Application by AQUIND Limited for an Order granting Development Consent for the AQUIND Interconnector Project (PINS reference: EN020022)

Mr. Geoffrey Carpenter and Mr. Peter Carpenter (Registration Identification Number: 20025030)

**Interested Party Comments on the Applicant's Responses (REP3-014)
to the Carpenters' Comments (REP2-027)**

**Illustrative converter station layout and equipment included in noise model**

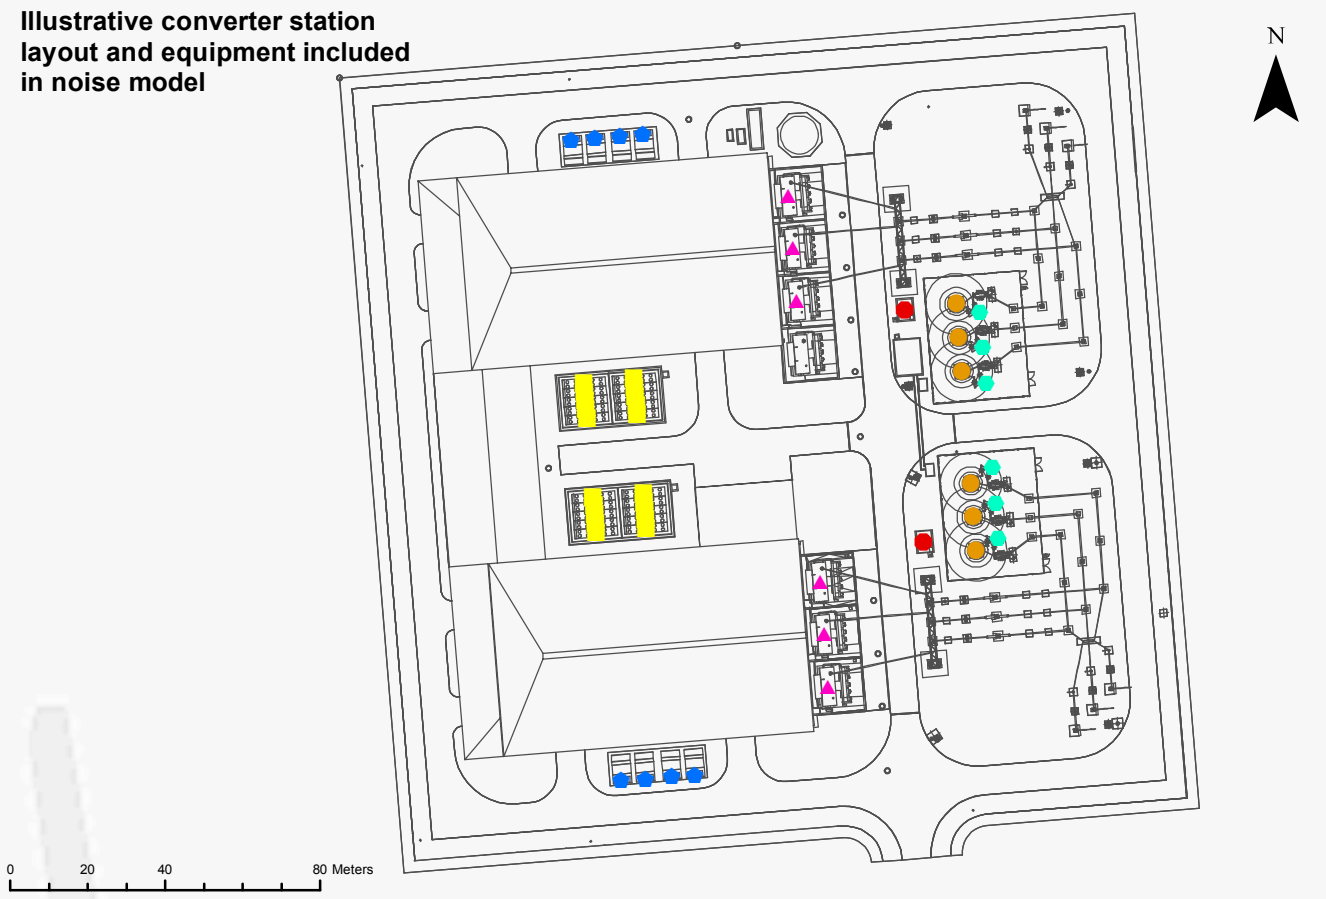
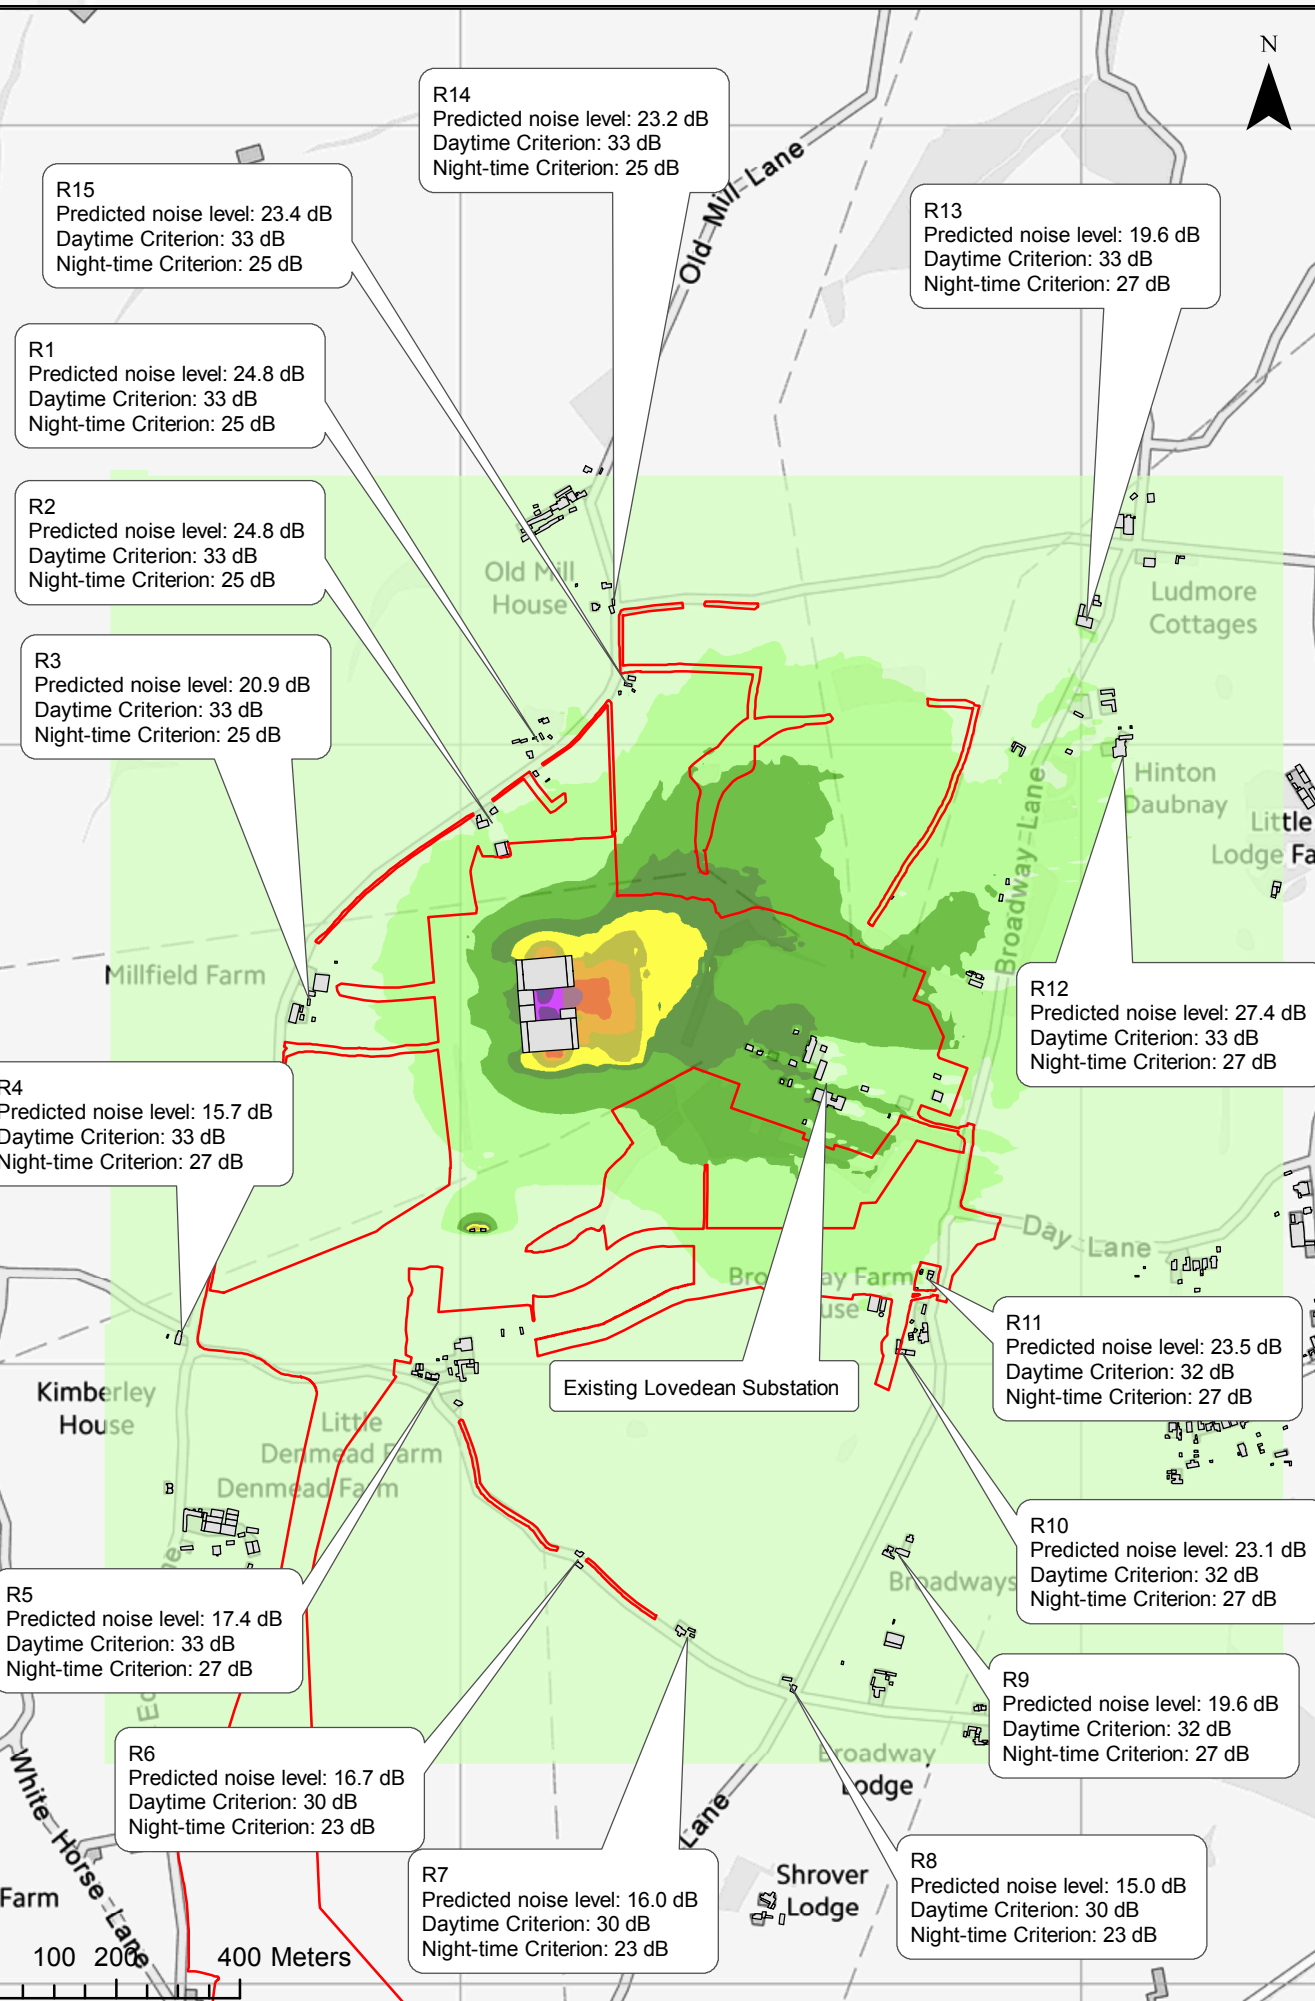
<p>Argument contained in Carpenter's comments on Applicant's response to Relevant Representations under Deadline 1 (REP2-027)</p> <p>(Paragraph Number)</p>	<p>AQUIND response (provided at Deadline 3 in section 3 of Table 2.5 of REP3-014)</p>	<p>BLAKE MORGAN COMMENT AT DEADLINE 4</p>
	<p>vibration (please for example see page 2-9 of the Onshore Outline Construction Environmental Management Plan (document number 6.9). Paragraph 24.4.1.2 of chapter 24 of the Environmental Statement (document number 6.1.24) states that Little Denmead Farm was part of 'Measurement Position 1' of the Promotor's baseline noise survey. Little Denmead Farm is also referred to as 'R5' in the context of it being a sensitive receptor to noise due to its location being within 300m of the proposed converter station (see paragraph 24.4.2.7 of Chapter 24 of the Environmental Statement). What is lacking from Chapter 24 is an analysis in layman's terms of what all the different sets of data presented for R5 mean and an explanation as to how the Promoter concluded that overall noise effects from the proposed works and the operation of the converter station would be "negligible". Until such information is provided, it is difficult to accept the Promoter's conclusions.</p>	<p>079) for a non-technical description of the conclusions identified in Chapter 24 of the ES.</p> <p><i>The data collected during the Applicant's baseline noise survey were used to inform the noise criteria used in the operational assessment of converter station noise. As explained in Paragraph 24.6.2.18 of the ES (APP-139) and Paragraph 17.2.5.2 of the ES Addendum (REP1-139), the operational effects of the converter station are expected to be negligible at Little Denmead Farm. For the operational assessment, the term 'negligible' is used to describe an effect where the noise level from the converter station is equal to or below the noise assessment criterion (i.e. does not exceed the existing background noise level at a given receptor).</i></p> <p><i>Please refer to the information in the paragraphs below in response to the Construction noise related query raised in Paragraph 8.1 of the Interested Parties' Written Representation (REP1-232)."</i></p>	<p>conclusion that there will be a negligible effect in relation to these two specific receptors. For example, paragraph 24.3.1.2 of REP1-079 states that "Additional construction stage mitigation, such as consideration of programme changes to reduce residents' noise exposure, is also specified for some areas of construction where work is being undertaken during sensitive periods and/or very close to sensitive receptors.." but it does not state which residents and which sensitive receptors will benefit from this. Paragraph 24.3.1.3 of REP1-079 also states "Additional mitigation has been recommended to reduce Converter Station noise levels at one receptor." Further, it remain unclear whether these relate to Little Denmead Farm?</p> <p>The Applicant has failed to date to provide particular responses and gaps remain. We maintain our representations in this regard.</p> <p>We note, in the Applicant's recent reply, their assertion that "negligible" is used to describe an effect where the noise level from the Converter Station is equal to or below the noise assessment criterion (i.e. does not exceed the existing background noise level at a given receptor). However, Table 24.3 of Chapter 24 of the Environmental Statement (APP-139) states for construction noise to be negligible it must be less than or equal to 65dB during the day, less than or equal to 55dB during the evenings and weekend,</p>

<p>Argument contained in Carpenter's comments on Applicant's response to Relevant Representations under Deadline 1 (REP2-027)</p> <p>(Paragraph Number)</p>	<p>AQUIND response (provided at Deadline 3 in section 3 of Table 2.5 of REP3-014)</p>	<p>BLAKE MORGAN COMMENT AT DEADLINE 4</p>
			<p>and less than or equal to 45dB during the night. The Applicant also invites us to read REP1-079 but Chapter 24 of the Non-Technical Summary (REP1-079) does not detail how the overall noise effects from the proposed works and the operation of the converter stations would be negligible. Therefore, our question is what is negligible? Is it the value given by the Applicant in Table 24.3 or is it the description given by the Applicant in their most recent comment?</p> <p>In addition, we note that the Applicant has defined the noise assessment criterion at Little Denmead Farm to be 33dB. See paragraph, 24.4.5.6, Table 24.9 (APP-139). This noise assessment criterion has been taken from the background noise level for measurement position 1, found at Table 24.15 (APP-139) as outlined at paragraph 24.2.4.8 (APP-139) and as such is 33dB. However, despite background noise levels being 33dB, average ambient noise level averaged as 45dB for the day and 43dB for the night at measurement position 1, as seen at paragraph 24.5.1.5, Table 24.15 (APP-139).</p> <p>There is no explanation as to why background noise levels have been used rather than average ambient noise levels to form the 'noise assessment criterion'.</p> <p>We request for the Applicant to provide this</p>

<p>Argument contained in Carpenter's comments on Applicant's response to Relevant Representations under Deadline 1 (REP2-027)</p> <p>(Paragraph Number)</p>	<p>AQUIND response (provided at Deadline 3 in section 3 of Table 2.5 of REP3-014)</p>	<p>BLAKE MORGAN COMMENT AT DEADLINE 4</p>
			<p>explanation and why it has chosen an elevated and not a lower baseline as background. Raising the baseline reduces (potentially artificially) the real noise impacts generated by the Application Development.</p> <p>In addition, we cannot identify in the documents provided by the Applicant any resultant noise predictions in decibels ("dB") incorporating current ambient and background noise readings.</p> <p>The Applicant has provided figures for the operation noise levels, construction noise levels, pre-existing background noise levels, and pre-existing ambient noise levels but does not provide the expected resulting uplift in noise levels during construction and operation. Dealing with the figures provided at Tables 24.21-24.24 (APP-139), the Applicant has not commented whether the noise levels during construction are those calculated in absence of the background noise levels or in addition to the pre-existing background noise.</p> <p>Therefore, in relation to Table 24.3 (APP-139) we are unable to tell if the noise that is being measured as 'negligible' is the total noise levels of the area with both construction and background included, or if the Applicant is measuring the construction noise levels in isolation.</p> <p>In addition, if the Applicant is using total noise</p>

<p>Argument contained in Carpenter's comments on Applicant's response to Relevant Representations under Deadline 1 (REP2-027)</p> <p>(Paragraph Number)</p>	<p>AQUIND response (provided at Deadline 3 in section 3 of Table 2.5 of REP3-014)</p>	<p>BLAKE MORGAN COMMENT AT DEADLINE 4</p>
			<p>levels, does the Applicant use the background noise levels of 33dB or ambient noise levels of 45dB, as depending on which one we consider that this might make a material difference to the final calculation of dB readings caused by the construction and operation of the Application Development?</p> <p>We request that if the Applicant is using background noise levels to calculate total noise levels to provide their reason for doing this.</p>
<p>3.</p>	<p>Paragraph 8.2 of our Clients' Written Representations (REP1-232) SUBMITTED AT DEADLINE 1: :</p> <p>Paragraph 3.7.1.3 of Chapter 3 of the Environmental Statement (document number 6.1.3) states that the construction works and activities relating to the converter station area is anticipated to take place in 10-hour shifts over six days a week, between 8am and 6pm, with one hour either side of these hours for start-up/shut down activities, oversized deliveries and for the movement of personnel. This will cause significant noise impacts for our Clients as it will affect our Clients' peaceful enjoyment of their property. One of our Clients is not in good health, has recently suffered from a stroke, has underlying heart conditions, and has asthma. Given the proximity with which our Clients will live to the works, they</p>	<p>Paragraph 8.2:</p> <p><i>"The construction core working hours for the Converter Station area (Works No. 1 and 2) are specified in Requirement 18 of Schedule 2 of the dDCO as being between 0800 and 1800 hours on weekdays and between 0800 to 1300 hours on Saturdays, with start-up and shut-down activities up to an hour either side of the core working hours. These are standard construction working hours.</i></p> <p><i>Construction noise predictions at surrounding residential receptors, including Little Denmead Farm (R5), for the key work stages, has been</i></p>	<p>The Applicant is side-stepping our point and has not addressed it. Instead, it merely re-iterates its responses already provided at Deadline 2. We have already provided an answer on this point at row 17 of our submissions for Deadline 3 (REP3-043.). The Applicant does provide additional references to information relating to noise and vibration predictions, but these do not answer the points we have made in relation to our Client's health.</p> <p>To summarise Tables 24.21 to 24.24 of Chapter 24 of the ES (APP-139), in relation to our Clients.</p> <ol style="list-style-type: none"> 1. Construction of main site access road – 55dB – Negligible 2. Establishment of car parking and site

<p>Argument contained in Carpenter's comments on Applicant's response to Relevant Representations under Deadline 1 (REP2-027)</p> <p>(Paragraph Number)</p>	<p>AQUIND response (provided at Deadline 3 in section 3 of Table 2.5 of REP3-014)</p>	<p>BLAKE MORGAN COMMENT AT DEADLINE 4</p>
	<p>will be highly impacted by the noise and vibration caused by the works. We are also instructed by our Clients that representatives of Promoter, in their limited dealings with our Clients, made verbal representations that the works would only operate for five days a week and between 8am and 5pm. This is not what is stated in the Environmental Statement and so served to give our Clients, at best unclear and, at worst misrepresentative information.</p>	<p><i>completed and are presented in Tables 24.21 to 24.24 of Chapter 24 of the ES (APP-139). These noise predictions have followed the principles of the methodology set out in in British Standard (BS) 5228-1:2009+A1:2014 Code of practice for noise and vibration control on construction and open sites – Part 1: Noise. Based on this assessment the construction noise impacts at Little Denmead Farm are assessed as being negligible.</i></p> <p><i>The vibration assessment has also concluded that there will be negligible effects at all receptors from Converter Station construction activities (Paragraph 24.6.2.14 of Chapter 24 of the ES (APP-139)). Further information regarding vibration is provided in table 2.6 of this document under Paragraph 3.6."</i></p>	<p>welfare area – 53dB negligible</p> <ol style="list-style-type: none"> 3. Construction of substructure of telecommunications buildings – 53dB – negligible 4. Construction of superstructure of telecommunications building – 52dB – negligible 5. Landscaping car parking and site welfare area – 52dB – negligible <p>The evidence leaves out of account the impact of the Converter Station on R5.</p> <p>We request evidence of the impact on R5 from the Converter Station and request an explanation as the basis for excluding the impact of the building of the substructure and the superstructure of the Converter Station for receptor R5 (Little Denmead Farm) from Tables 24.22 and 24.23. This seems a significant omission.</p> <p>In addition, we cannot identify in the Application documents any resultant noise predictions in decibels ("dB") incorporating current ambient and background noise readings.</p> <p>The Applicant has provided figures for the operation noise levels, construction noise levels,</p>

<p>Argument contained in Carpenter's comments on Applicant's response to Relevant Representations under Deadline 1 (REP2-027)</p> <p>(Paragraph Number)</p>	<p>AQUIND response (provided at Deadline 3 in section 3 of Table 2.5 of REP3-014)</p>	<p>BLAKE MORGAN COMMENT AT DEADLINE 4</p>
			<p>pre-existing background noise levels, and pre-existing ambient noise levels but does not provide the expected resulting uplift in noise levels during construction and operation. Dealing with the figures provided at Tables 24.21-24.24 (APP-139), the Applicant has not commented whether the noise levels during construction are those calculated in absence of the background noise levels or in addition to the pre-existing background noise.</p> <p>Therefore, in relation to Table 24.3 (APP-139), it is impossible to ascertain whether the noise that is being measured as 'negligible' is the total noise levels of the area with both construction and background included, or if the Applicant is measuring the construction noise levels in isolation excluding background.</p> <p>In addition, if the Applicant is using total noise levels, does the Applicant use the background noise levels of 33dB or ambient noise levels of 45dB, as depending on which one we consider that this might make a material difference to the final calculation of dB readings caused by the construction and operation of the Application Development?</p> <p>We therefore maintain our representations in this regard.</p>
